ENG-CDR21014-R3-GEC.pdf Markup Summary

Subject: Callout
Page Index: 6
Date: 4/29/2022 3:22:08 PM
Author: dsdrice
Color: ■
Layer:
Space:
Page Label: [1] 6 FINAL EROSION CONTROL PLAN

**C4.0**  
 Sheet 6 of 21

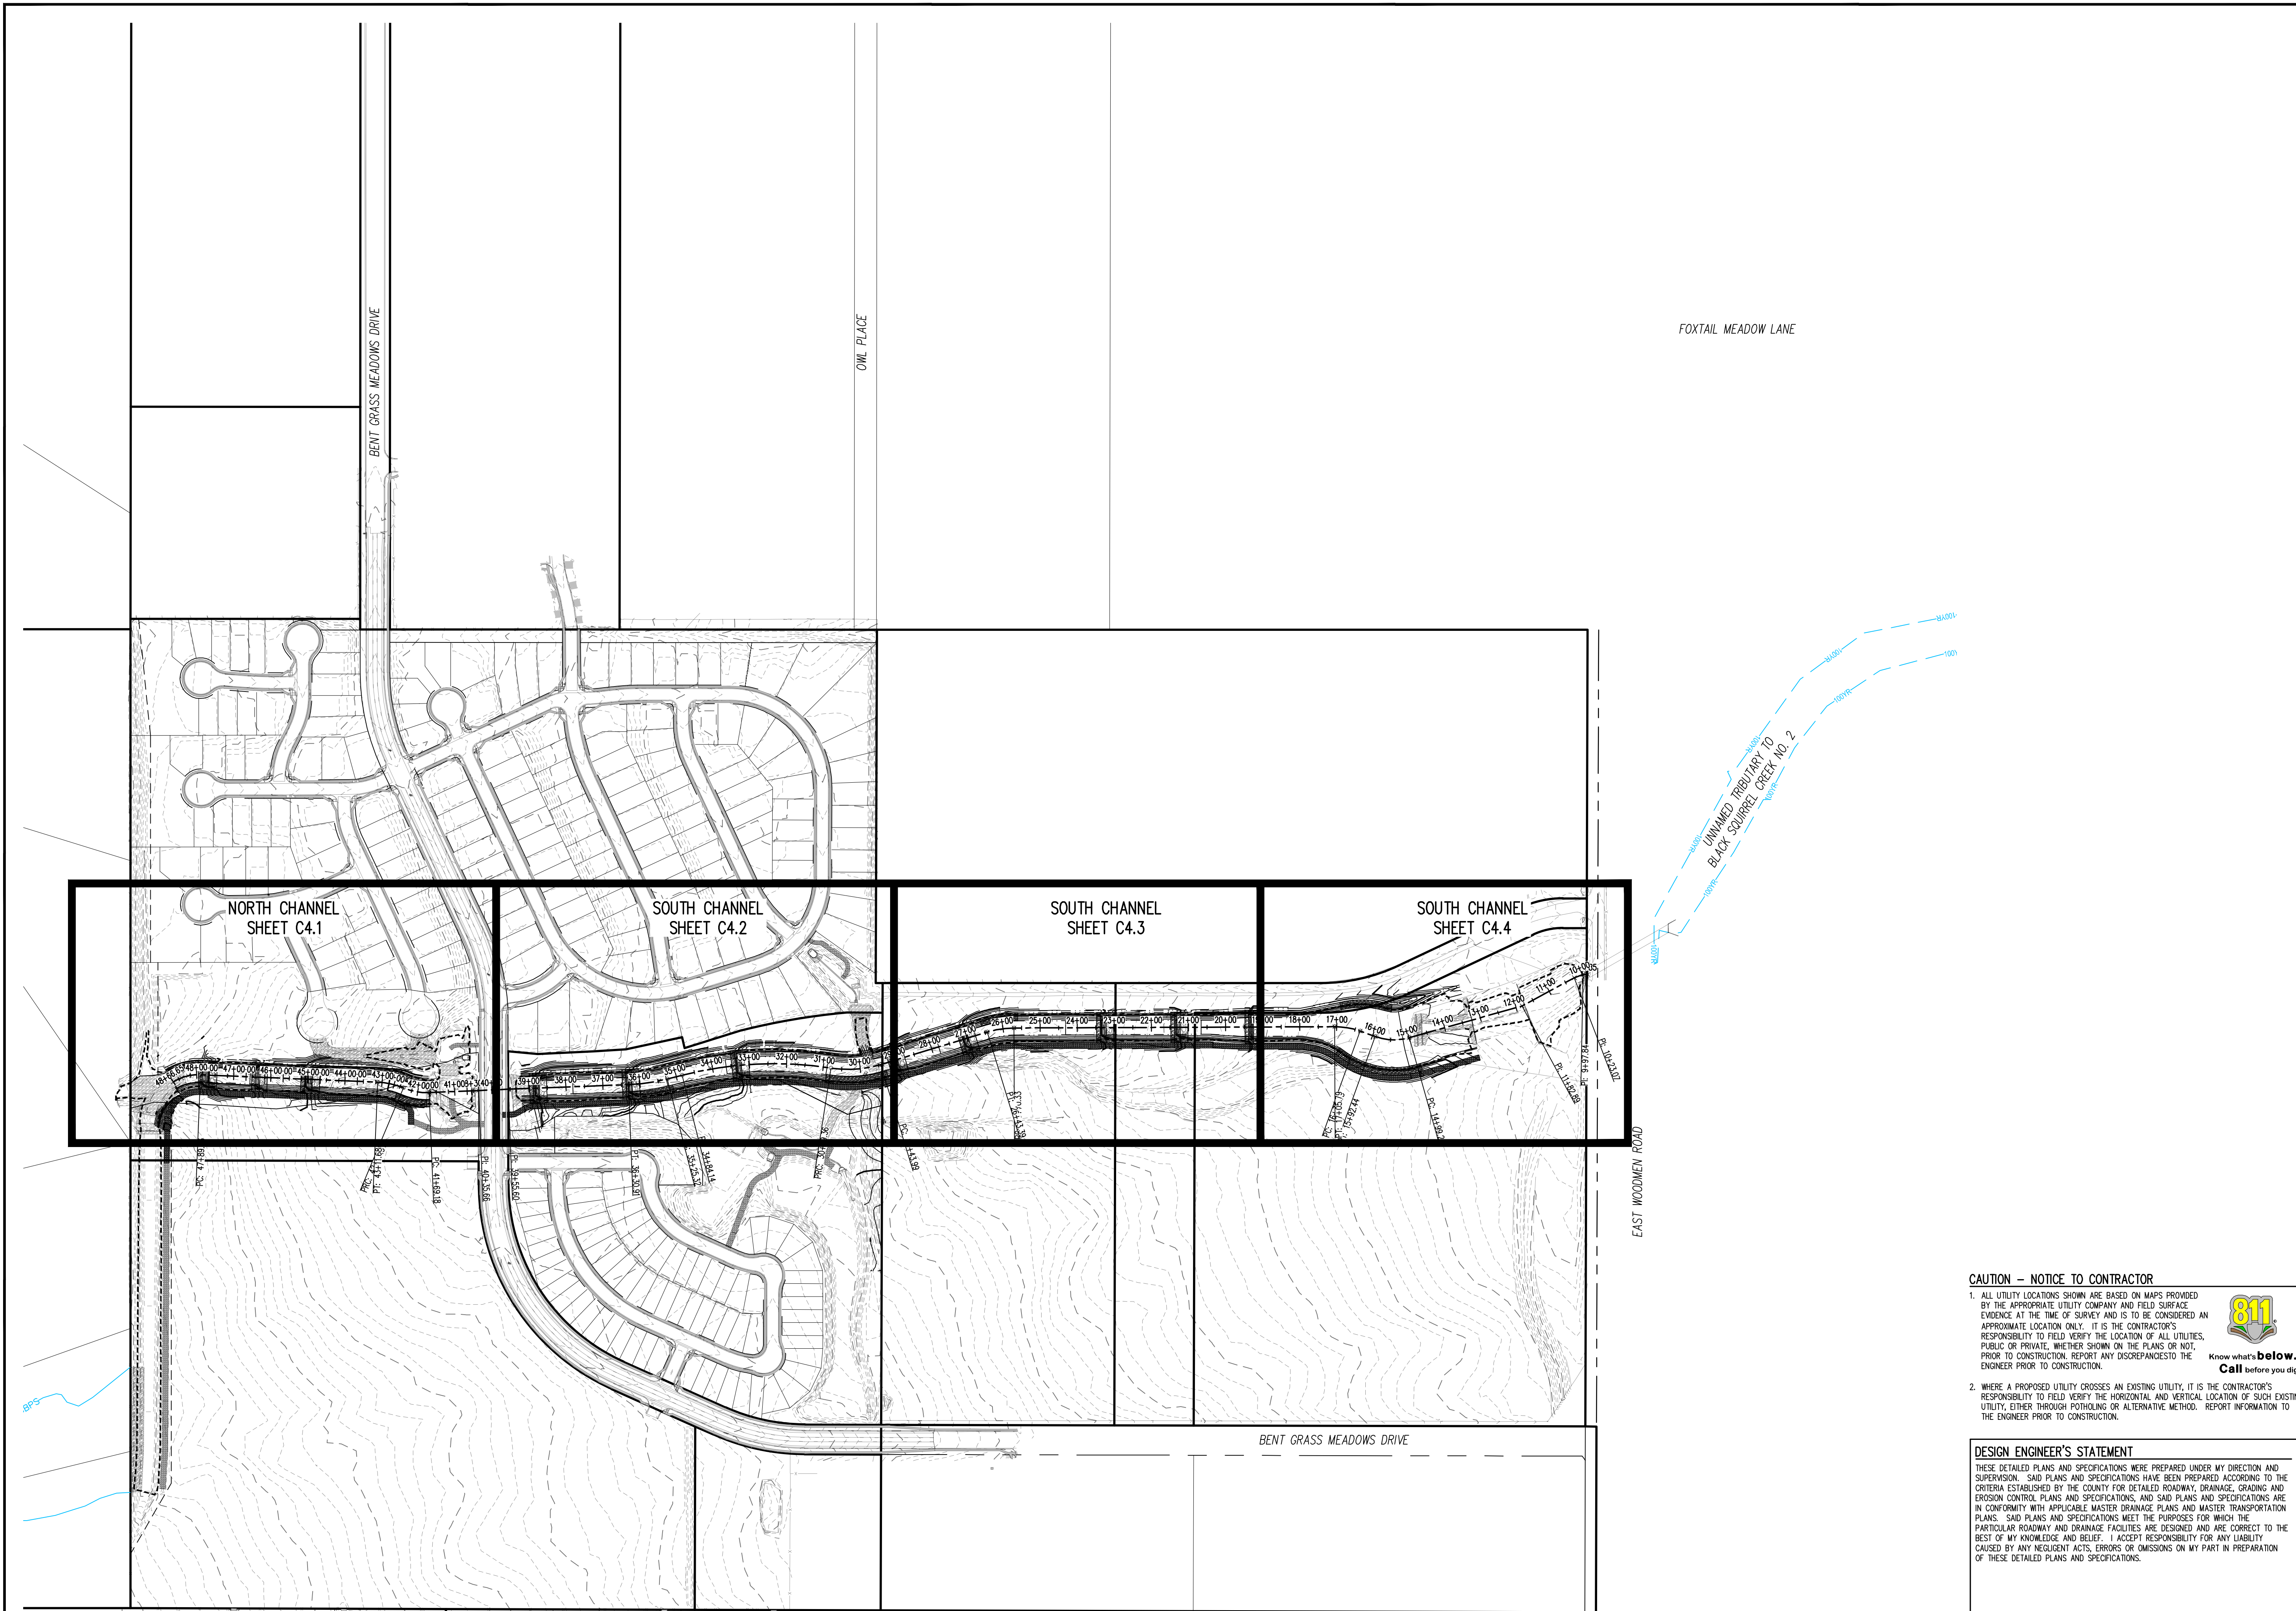
Label existing maintenance trail

Label access road grades at all drops

PS on top of riprap? Please clarify

Show access road with turnaround area

Show access road

Label existing features/improvements

This berm still needs to be flattened out

Adjust contour

Adjust grading

Adjust contours

Provide flow arrows

Add note that this area will need to be filled in prior to development

Add note that these areas will need to be filled in prior to development

Show and label existing trail/access road

Connect the access roads

Label existing road

Is all this berming needed?
